Consultation Response from KC, Highways Development Management (HDM)**2023/93539 Land adjacent to Ledgard Bridge Mill, Back Station Road, Mirfield, WF14 8NZ****Outline application, including the considerations of access, appearance, layout, and scale, for the erection of a six-storey building to host 76 residential apartments (C3 use) and ancillary works comprising demolition of vacant building, formation of new access, parking areas, open space and landscaping; erection of cycle and bin refuse storage structures.****Date Responded: 22/10/25****Responding Officer: A Darwin****Responding Ref: 10-9NW/31**

RECOMMENDATION: No objection, subject to planning conditions and S106 requirements set out at the end of this consultation response.

Project	Proposed residential scheme at Ledgard Bridge, Mirfield
Client	Binks Executive Homes Ltd, Cawthorne, Barnsley S75 4EJ
Dwg Title	(17001)13_Landscape Hub
Scale	1:200, 100 @ A1
Date	Nov 23

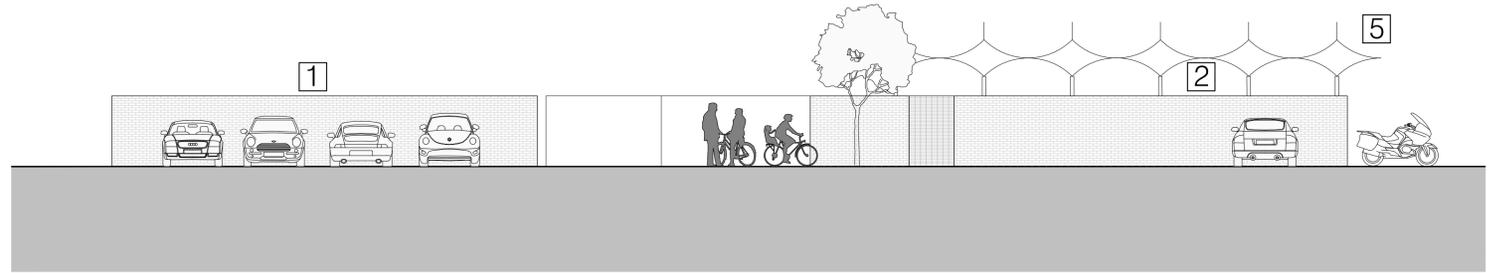
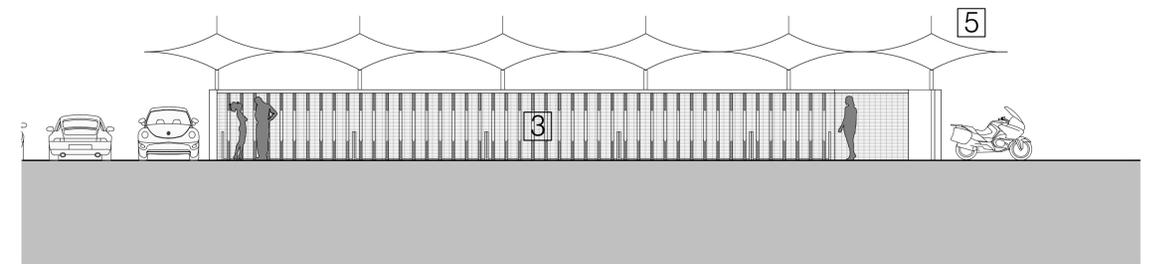
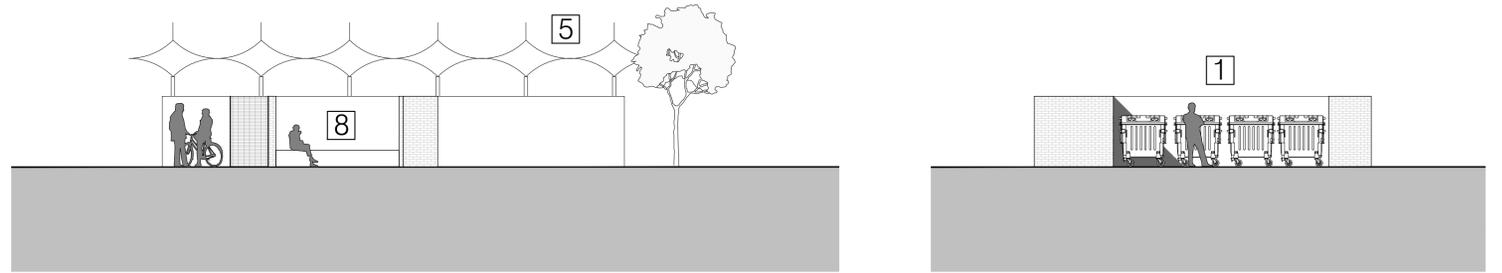
Secure/covered cycle stores are proposed for residents within the 'landscape hub' located within the main car park, which will cater for 140 no. cycles. Additional external space within the hub is also available for non-standard cycle types, in accordance with good practice. This level of provision will provide in excess of 1 space per new apartment, and will provide additional capacity for other existing/proposed residents to utilise.

In addition to the cycle parking for residents, additional short stay cycle parking is provided for visitors, with 18 no. spaces provided in the form of Sheffield stands.

The proposed cycle parking provision appears to be a good quality and is acceptable.

Unless otherwise agreed in writing, prior to occupation of the hereby approved development, the cycle parking indicated on drawing 17001/13 Revision D shall be provided and operational, and retained thereafter.
